RE: Daily Field Report for 01/13/2021
Lot 105 Anderson Creek Academy ACX (CMT) Spring Lake, NC
Building & Earth Project No : RD210021

Field Observations Report

Project Name:	Lot 105 Anderson Creek Academy ACX (CMT) Spring Lake, NC	Project Number:	RD210021
Client Name:	H & H Homes	Placement#:	FO-1
Contractor:	H & H Homes	Technician:	Michael Dammer
Monitoring:	DCP

MONOLITHIC SLAB FOUNDATION PLAN
ELEVATION B

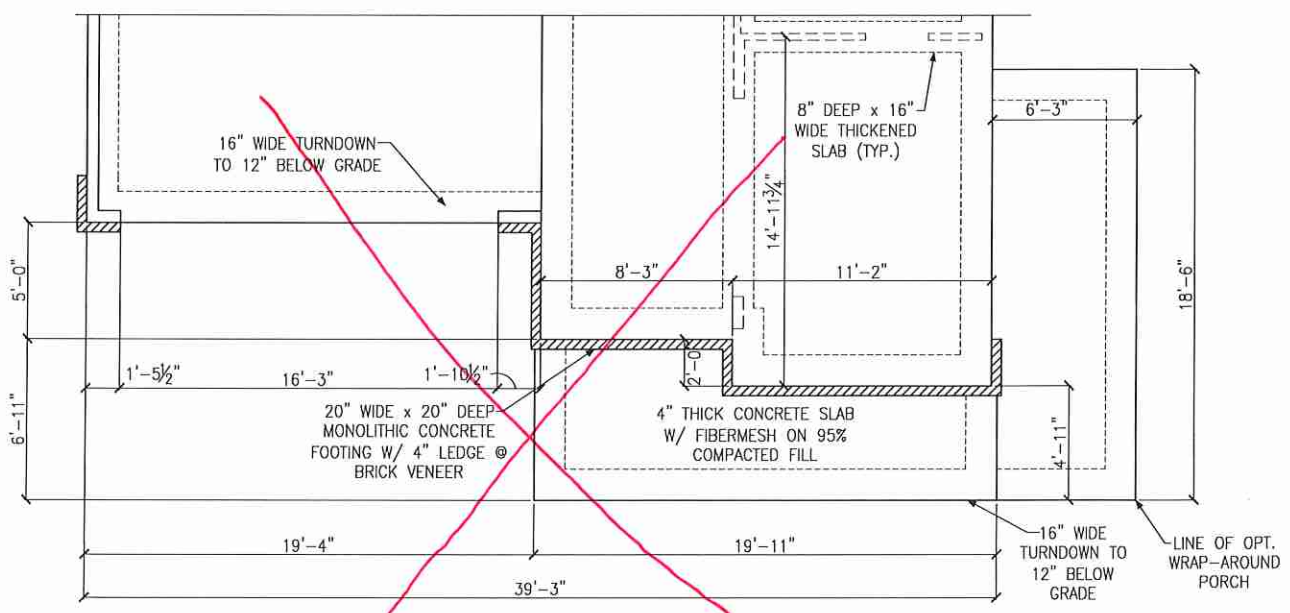
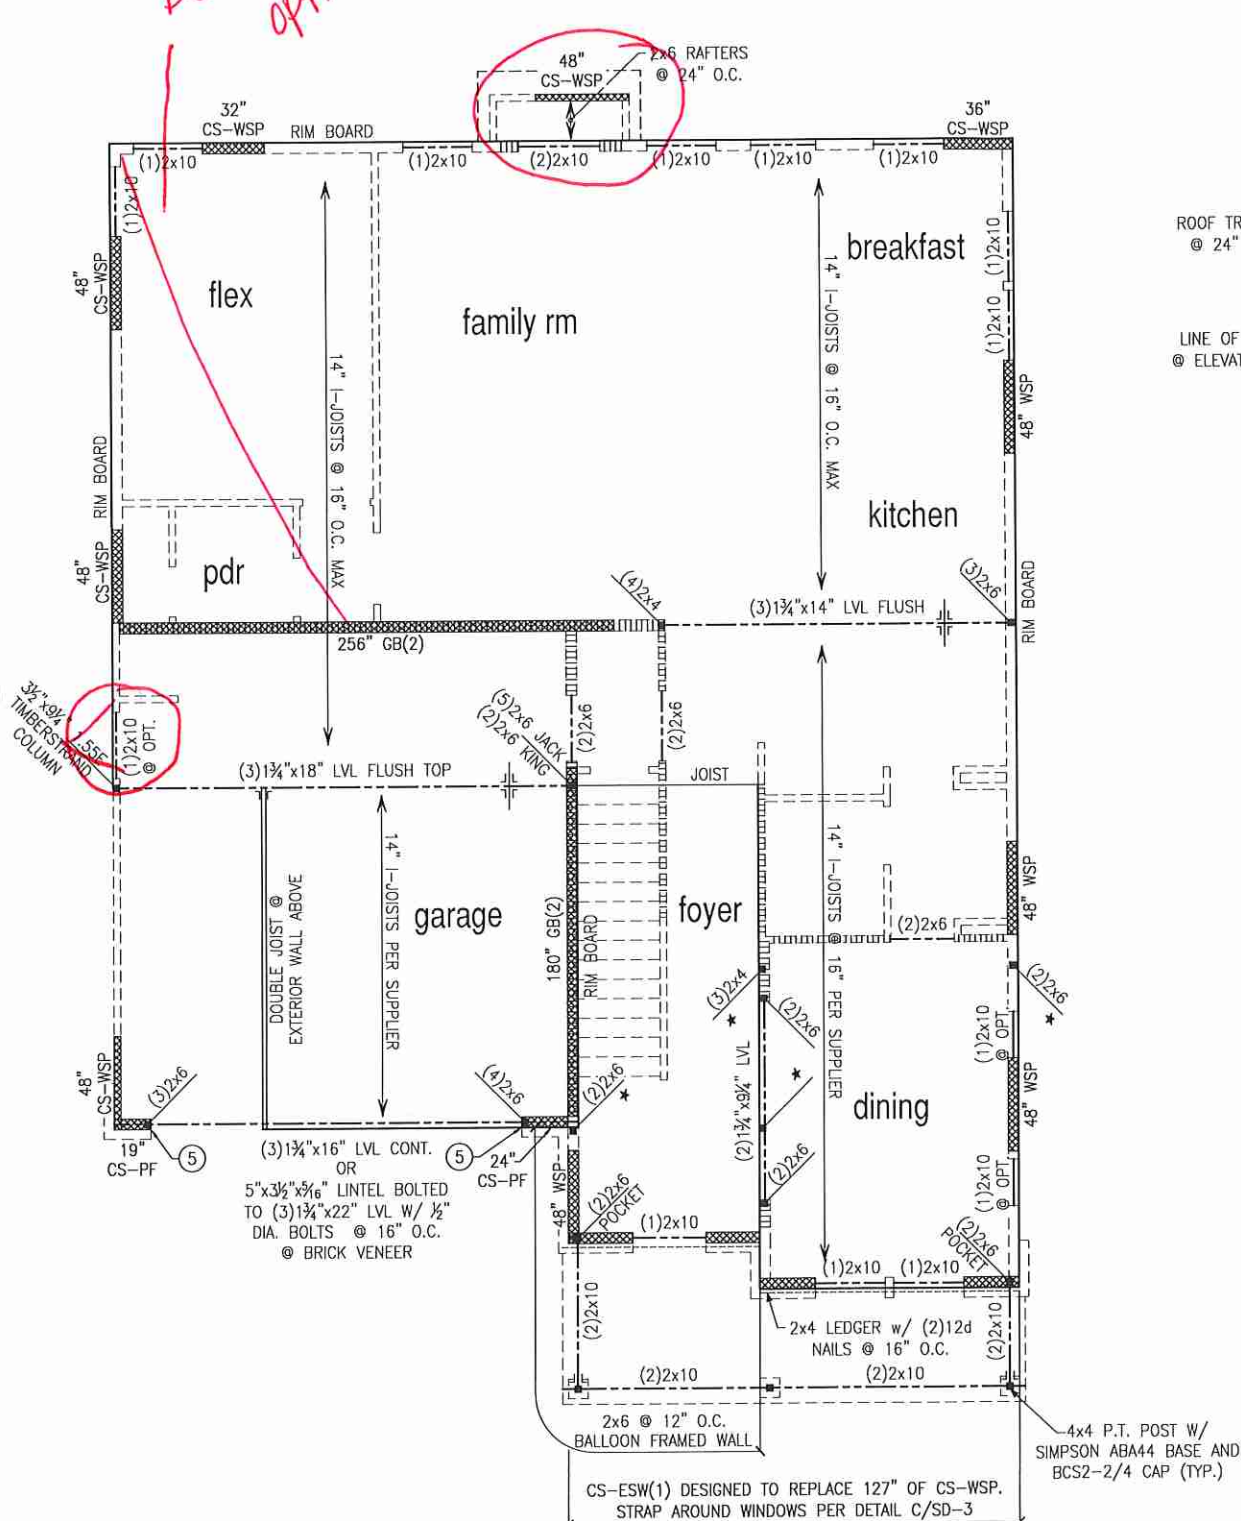
Comment 1 : Based on our observations and test results, we recommend the following: 1.

Undercut the back half perimeter footings an additional 2 feet from the planned bottom of the footings. 2. Install a tail drain to remove water from the foundation to drain to the lowest point. 3. Replace with washed NCDOT #57, wrapping in filter fabric such as Mirafi 140N.

-- Depth----"N"-----Soil Color---USCS-----
--- FSG --- 6----- Orange ----- SC-----
--- -1' ----- 7----- Orange ----- SC-----
--- -2' ----- 6----- Orange ----- SC -----
--- -3' ----- 3----- Orange ----- SC -----
--- -4' ----- 3----- Orange ----- SC ----- WATER ENCOUNTERED
--- -5' ----- 6.5---- Orange ----- SC -----

-- Depth----"N"-----Soil Color---USCS-----
--- FSG --- 6----- Orange ----- SC-----
--- -1' ----- 10----- Orange ----- SC-----
--- -2' ----- 8.5----- Orange ----- SC -----
--- -3' ----- 3.5----- Orange ----- SC -----
--- -4' ----- 5----- Orange ----- SC ----- WATER ENCOUNTERED
--- -5' ----- 5----- Orange ----- SC -----

1. Undercut the back half perimeter footings an additional 2 feet from the planned bottom of the footings.
2. Install a tail drain to remove water from the foundation to drain to the lowest point.
3. Replace with washed NCDOT #57, wrapping in filter fabric such as Mirafi 140N.
